From: Ian Hayward [REDACTED]
Sent: 11 May 2017 10:01
To: Anita Gardner
Subject: RE: A/64/17/DOC 1-6 The Cottrells, Angmering

Subject to the above amendment I would be minded to accept that that plans and details provided pertaining to condition 5 of A/173/16/PL are now acceptable from a highways perspective.

A		Flatbed delivery lorry added		04.05.17	
Rev		Description		Date	
Job Reference			Client		
New House The Cottrells Angmering			AM Homes Ltd		
Drawing Title			Drawing No		
Site Works Plan			AD962/03		
			Rev		
			A		
Date	Scale	Dwg Size	Plot Style	Drawn	Checked
28.02.17	1:100	A3	AD09xscale	TCG	AD

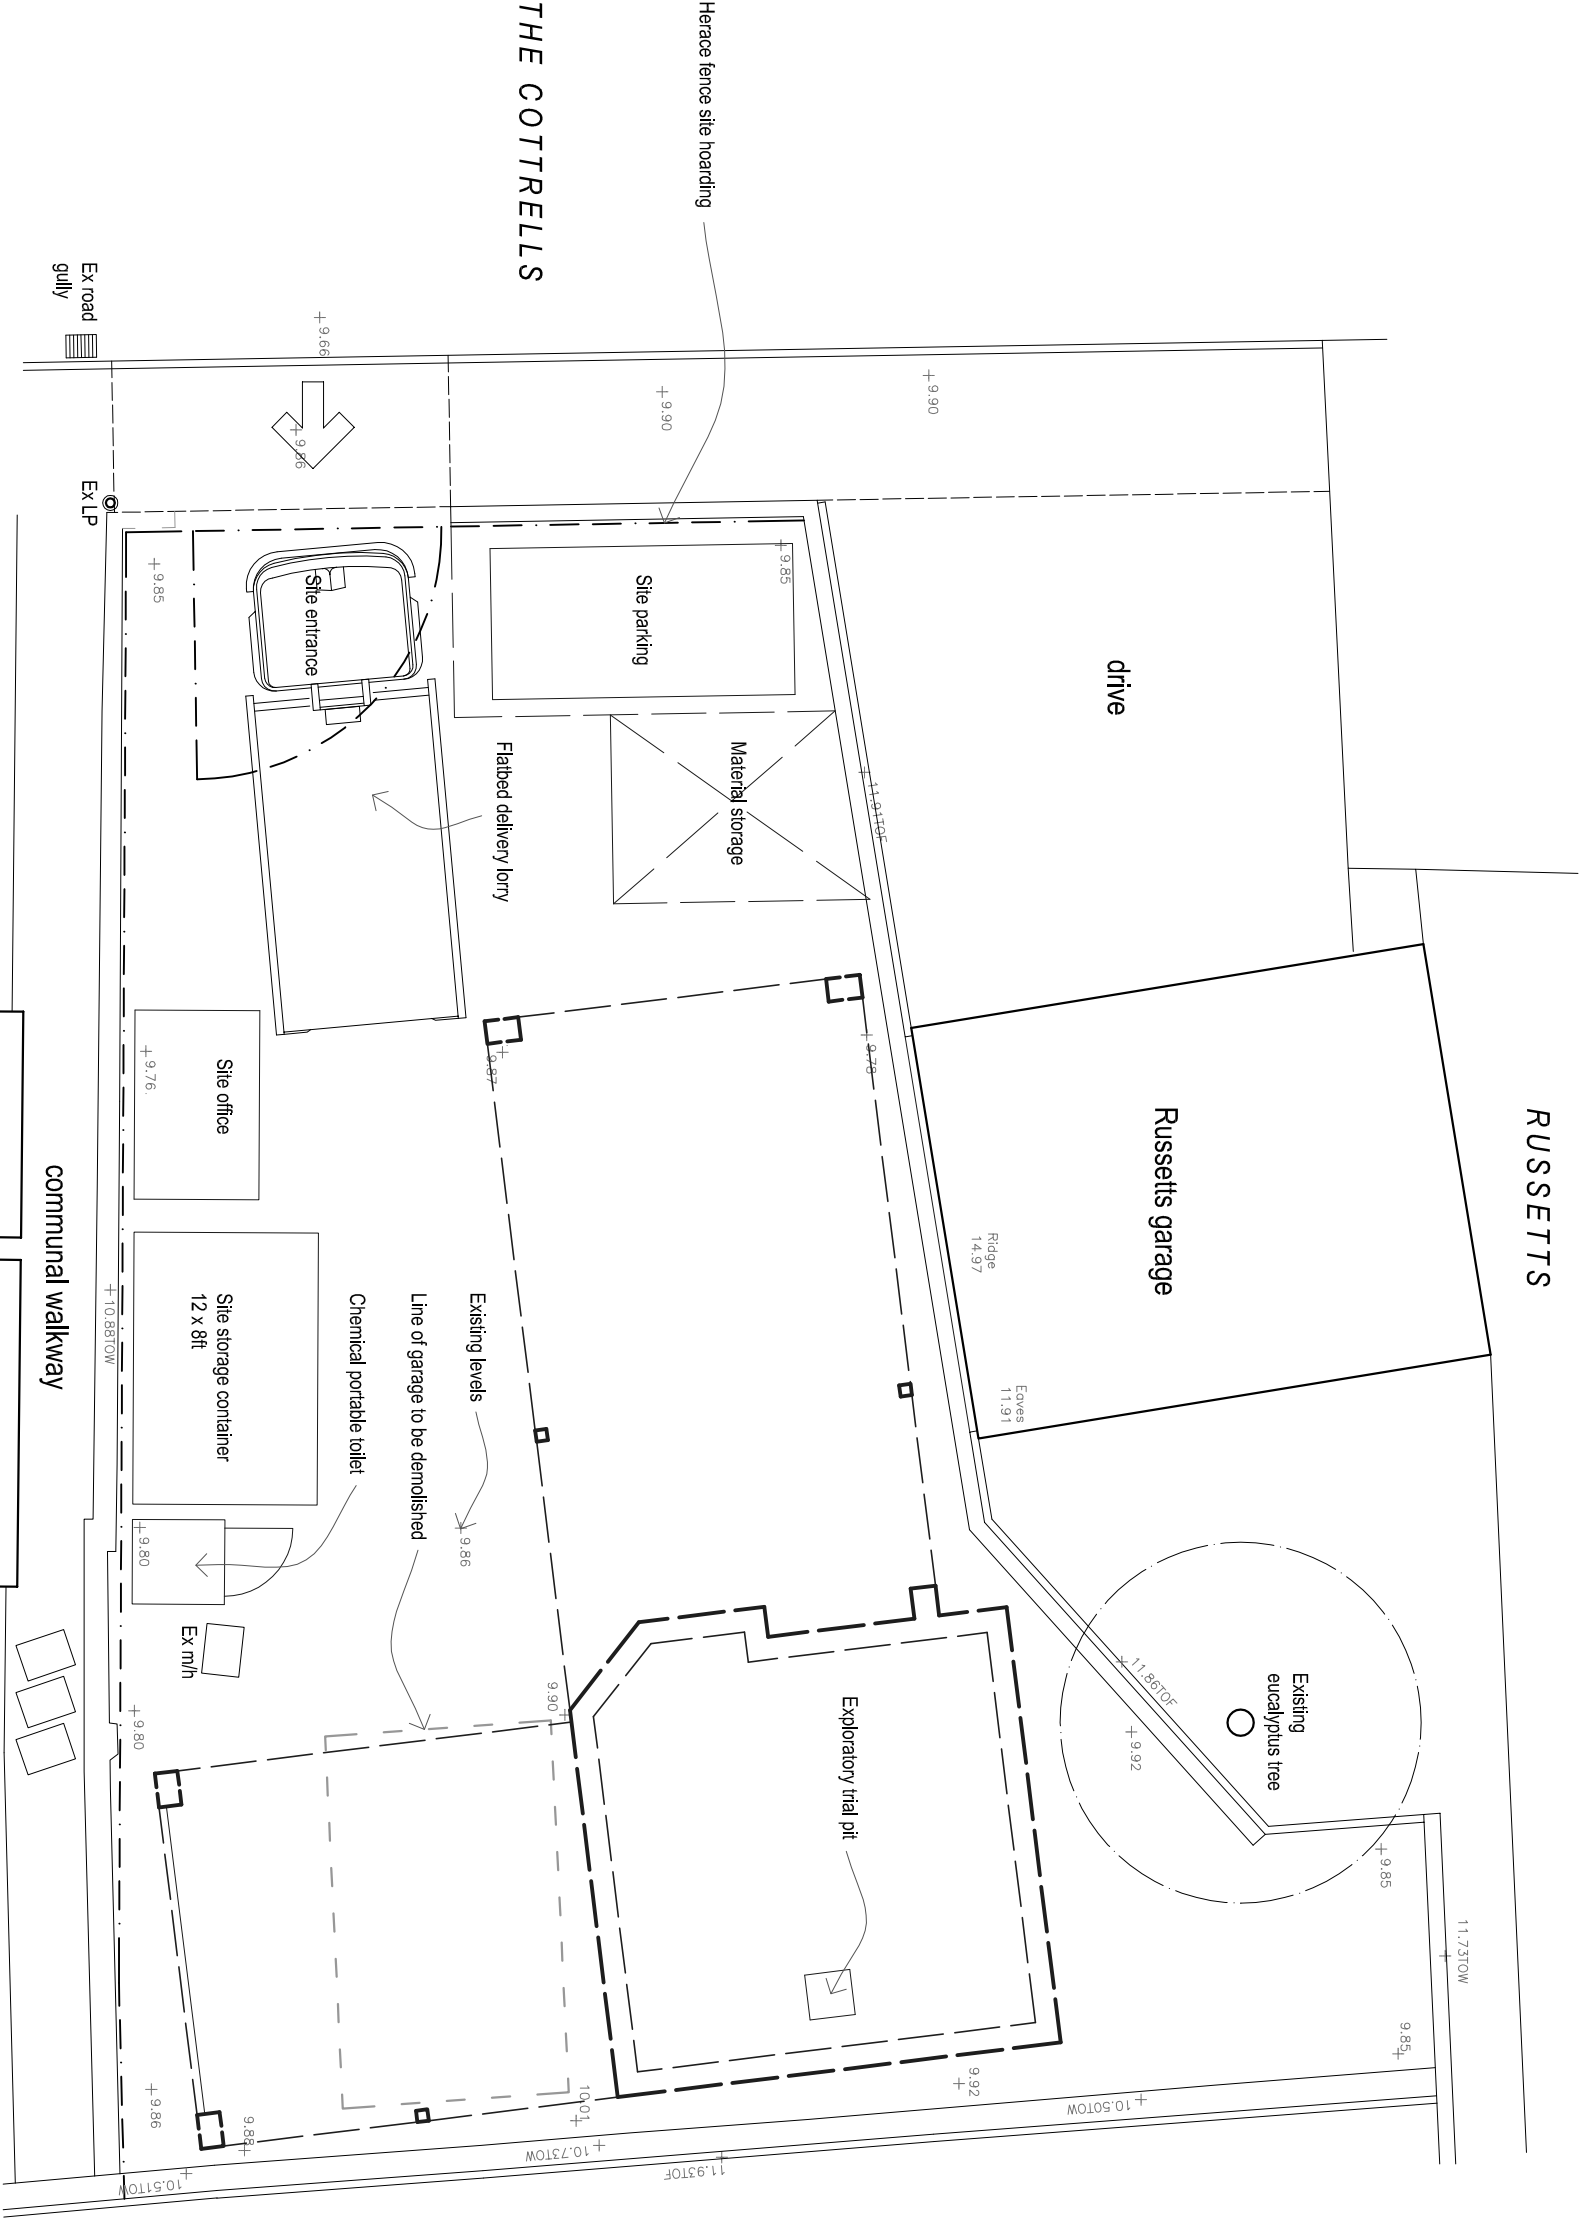
Thanks for this, based on the revised plan (AD962/03 A) the applicant has demonstrated how a flatbed delivery lorry could be facilitate on site. It is clear from this plan that such a delivery lorry would not be able to turn on site. I would therefore recommend an annotation on the plan detailing that any reversing movements into or out of the site by construction vehicles are undertaken with the use of a competent banksman.

It is appreciated that some deliveries may need to be undertaken from the roadside.
